Re: Planning Application 21/0009

Address: Land east of Chipping Lane Longridge

**Description: Discharge of Conditions of planning application 3/2018/0975.
Condition 5 - Emergency Link Road**

Title
 Hard Surfacing Plan

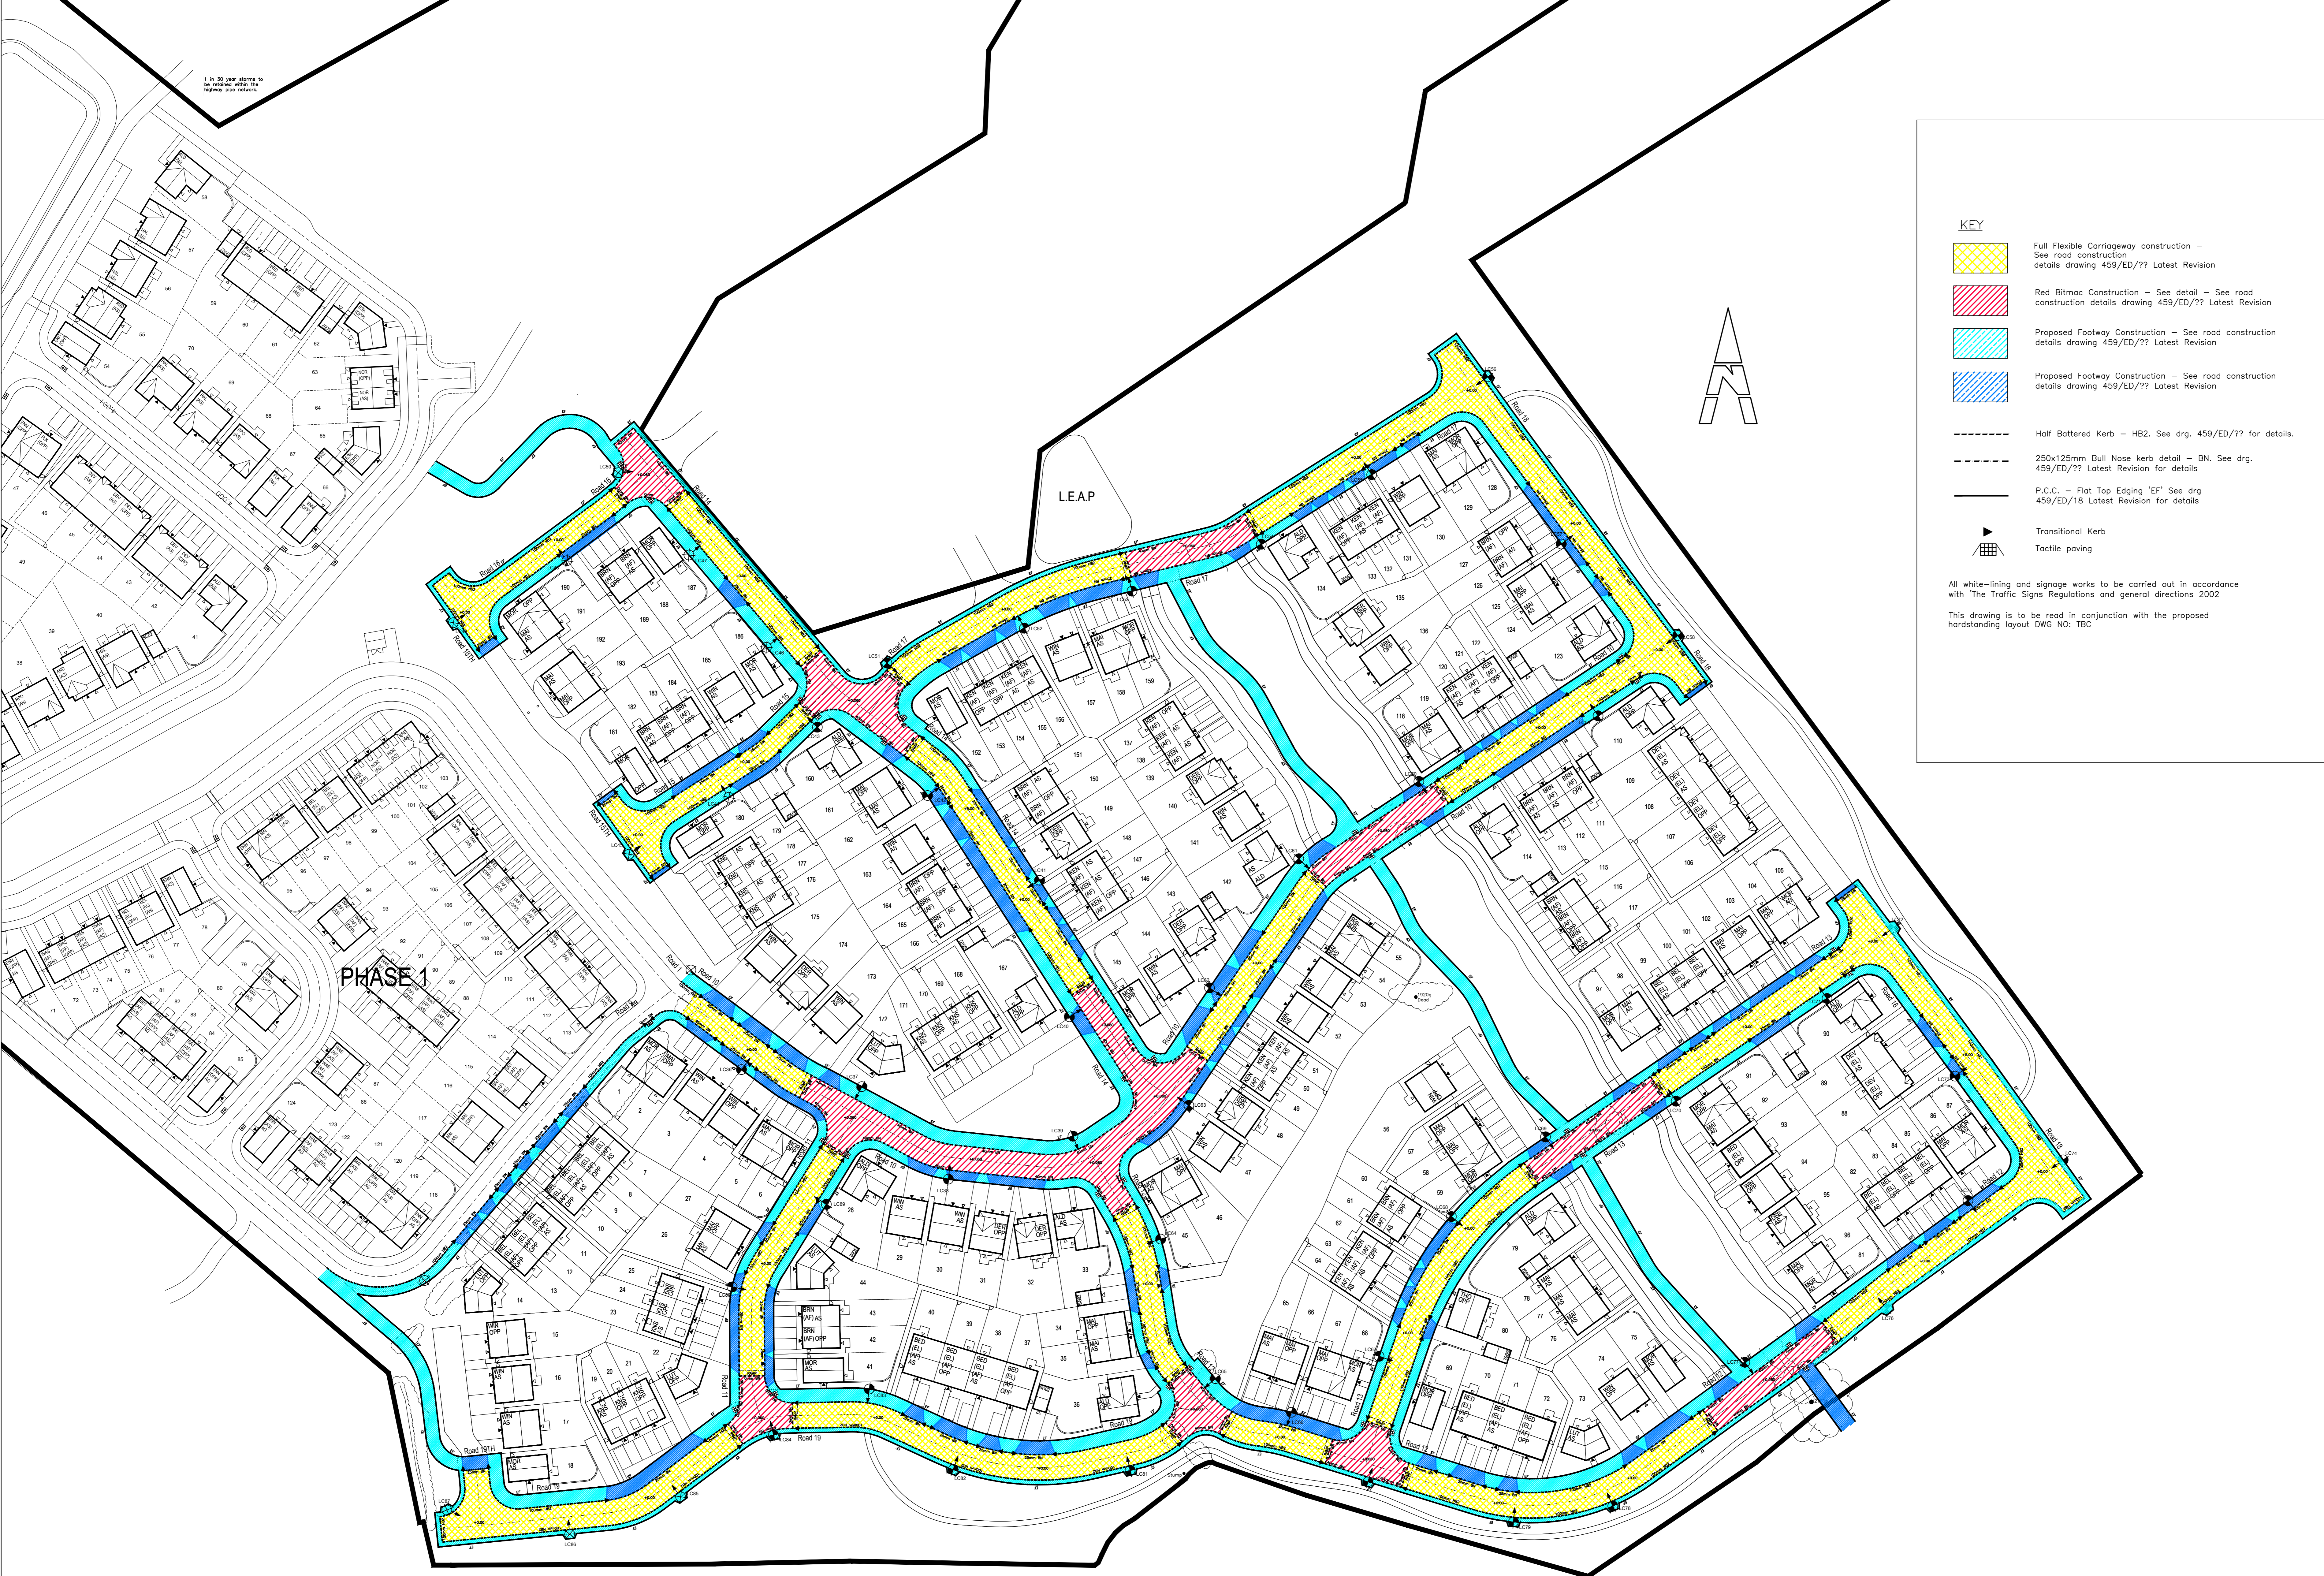
With respect to this application we would not raise any objections to the discharge of the condition.

The link road is also being used as a cycle track and is to be adopted as part of the estate road network. The construction details will need to be included in the section 38 agreement.
